# Rezoning Transportation Analysis

Petition Number: 2024-141

**From:** Jake Carpenter, PE

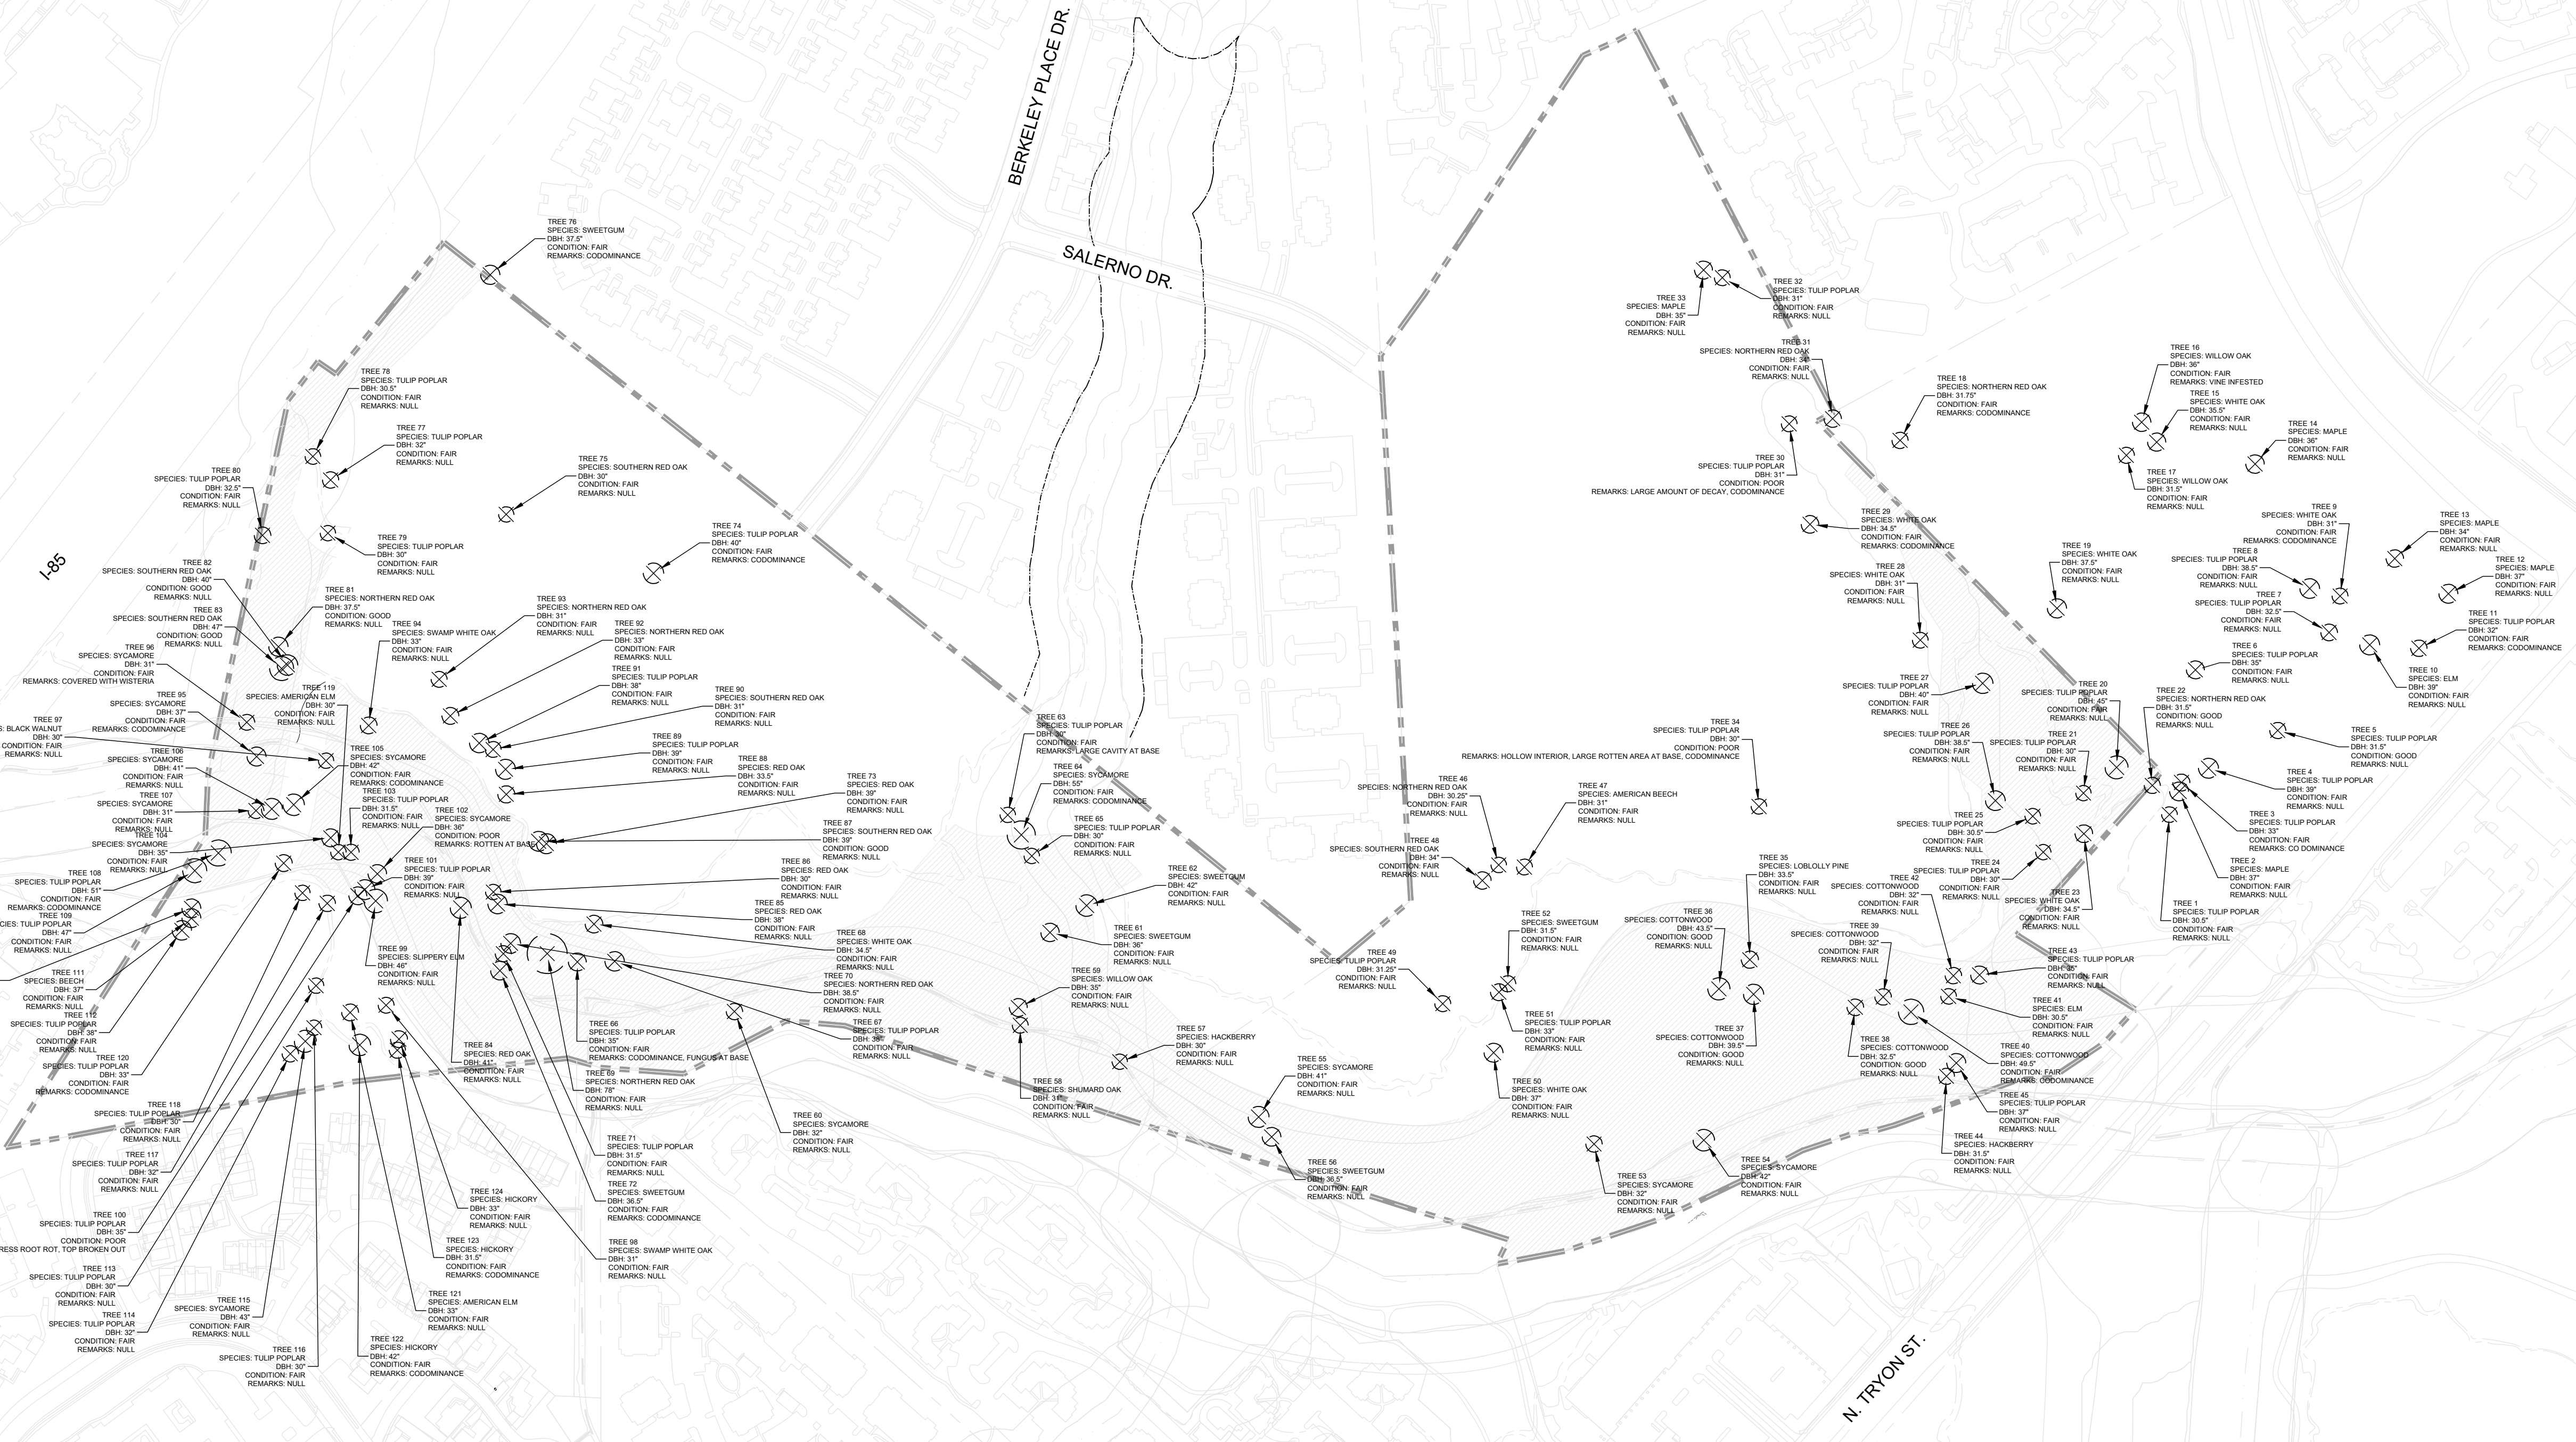
Label and dimension the curb and gutter from the centerline for each road on the site plan.

7. **CDOT REQUEST 02-26-2025: Reach out to CDOT to coordinate a roadway stub and ROW dedication which allows for a future connection to be made via stream crossing. This is an important connection in the overall public roadway network within the University Area.**
